**United Utilities Water PLC
Developer Services & Planning**
Warrington North WWTW
Gatewath Street
Warrington
WA5 1DS

Your ref: 3/2014/0053
Our ref: DC/14/332
Date: 29-JAN-14

Location: The Eaves, Pendleton Road, Wiswell, Clitheroe, BB7 9BZ
Proposal: Erect 1 No dwelling

EXISTING SITE PLAN - Scale 1:500 @ A3

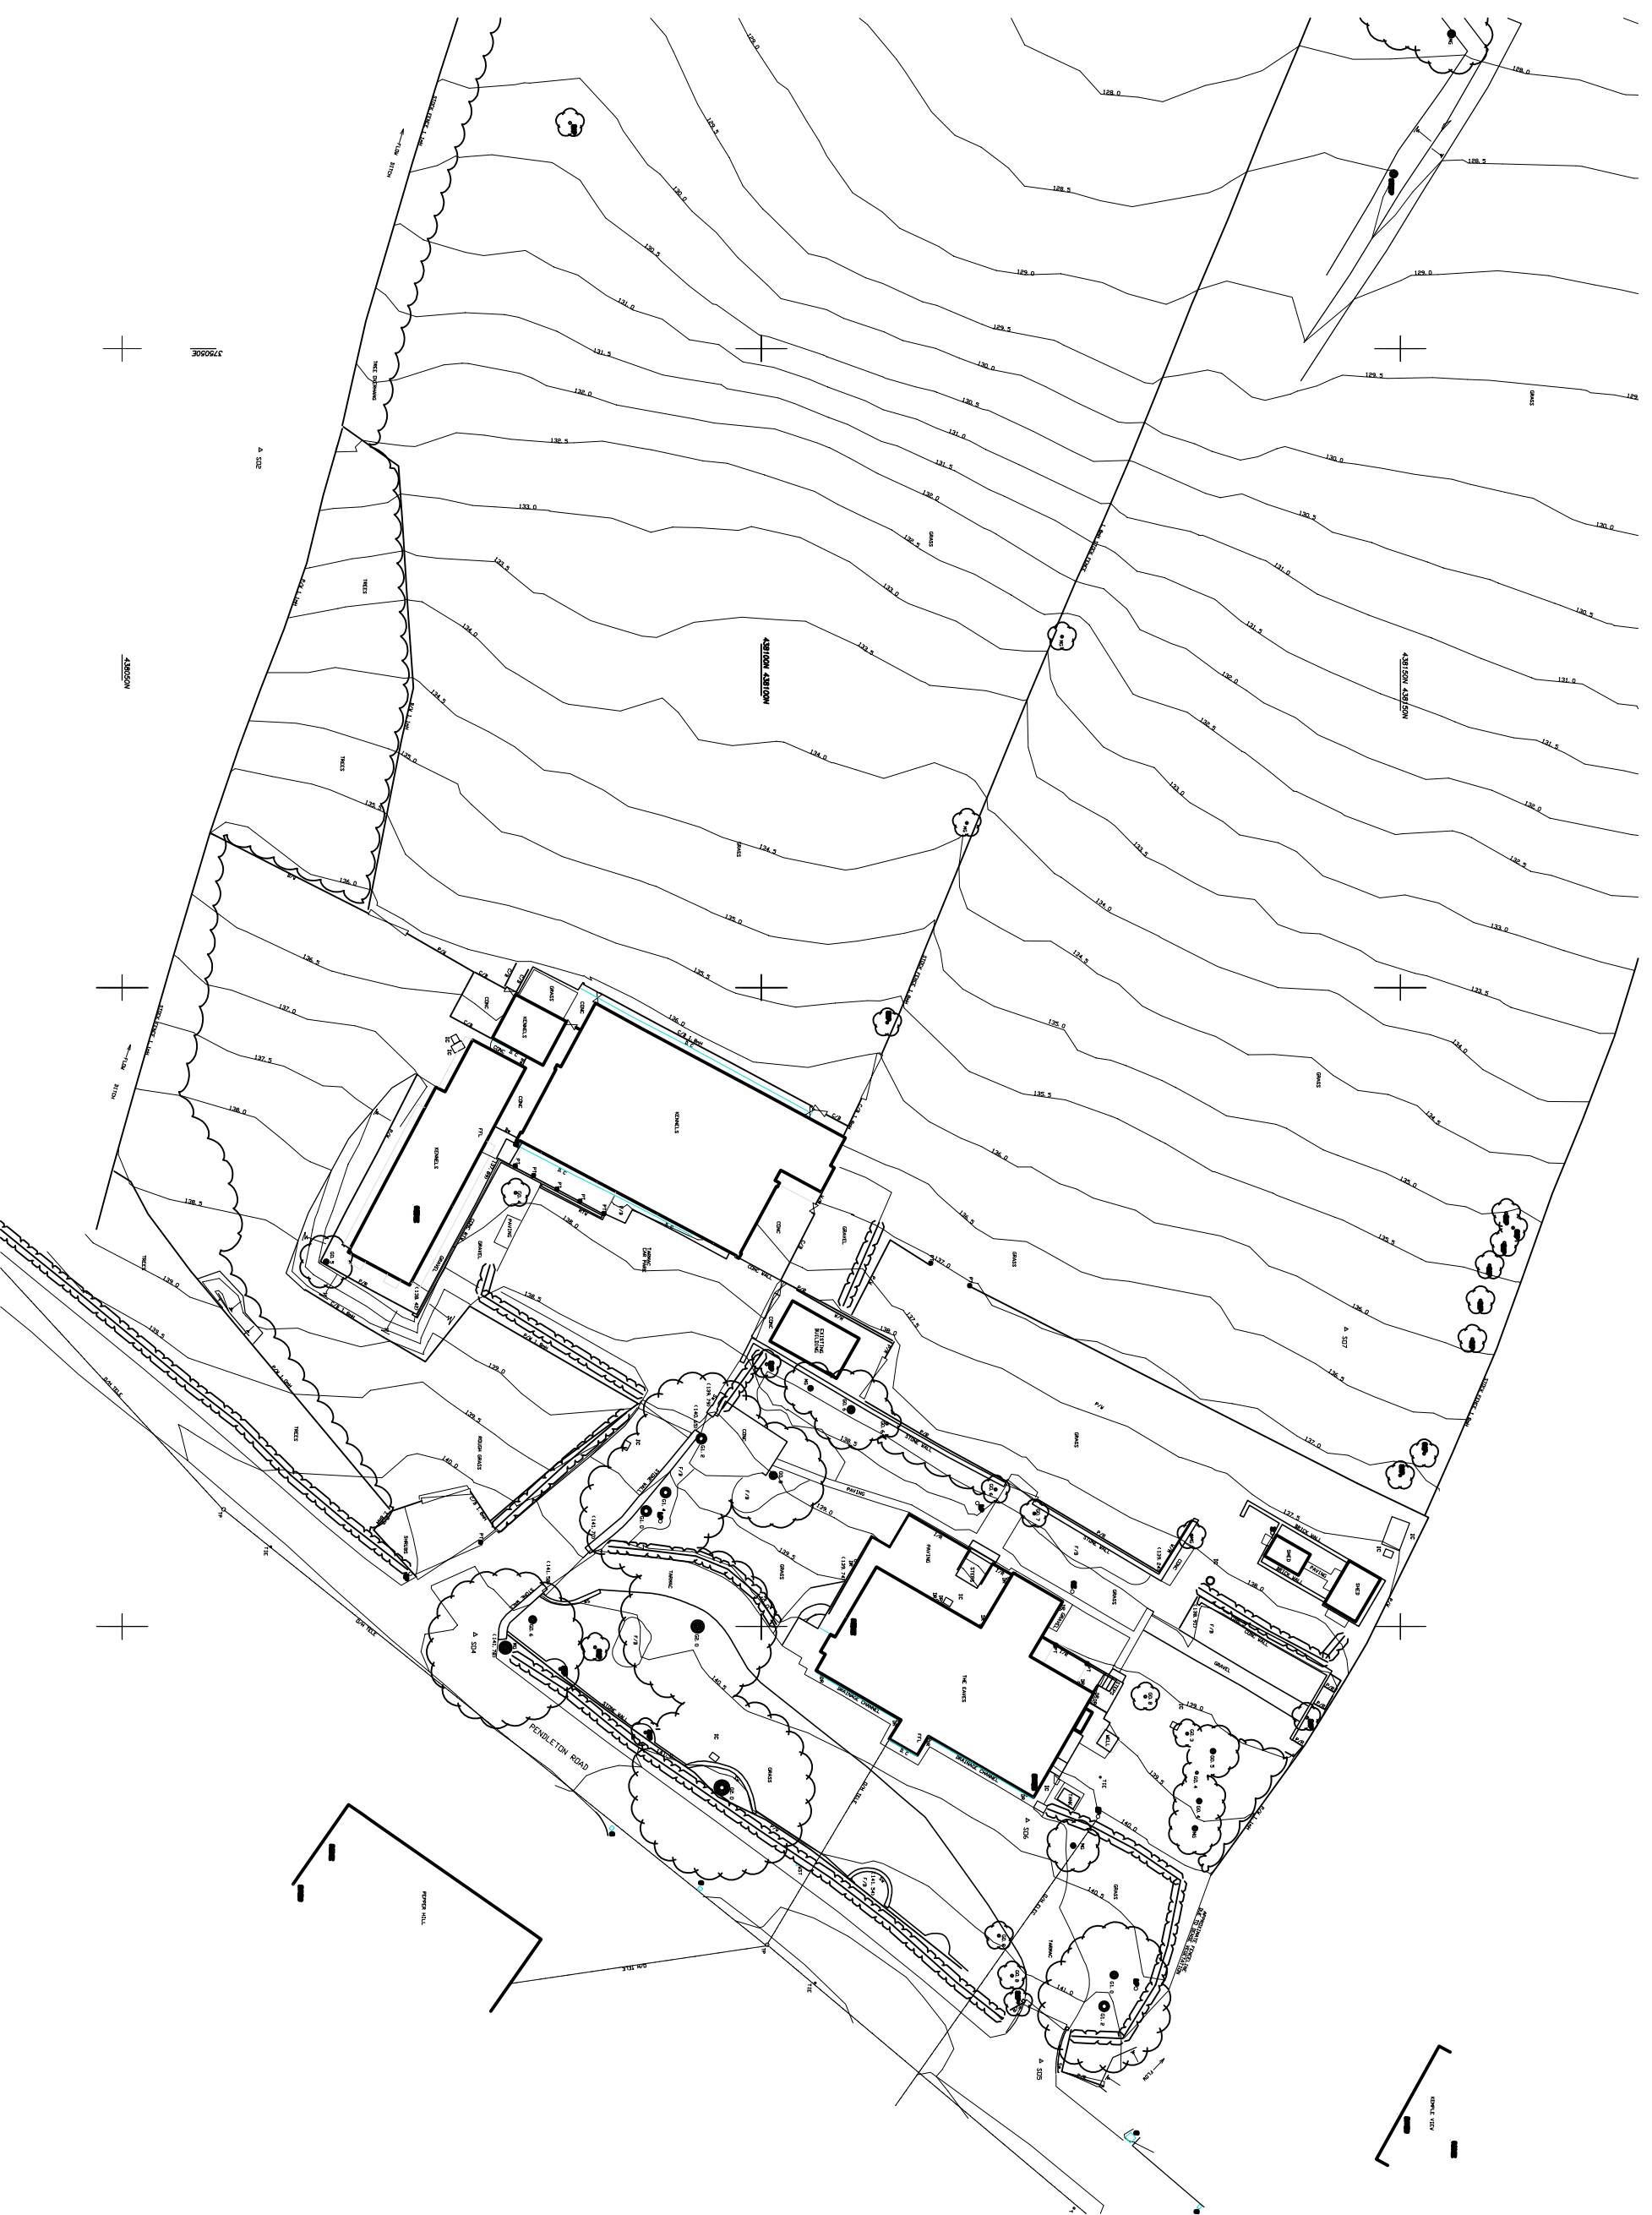
- A water main crosses the site. As we need access for operating and maintaining it, we will not permit development in close proximity to the main. A modification of the site layout, or diversion of the main at the applicant's expense, may be necessary.
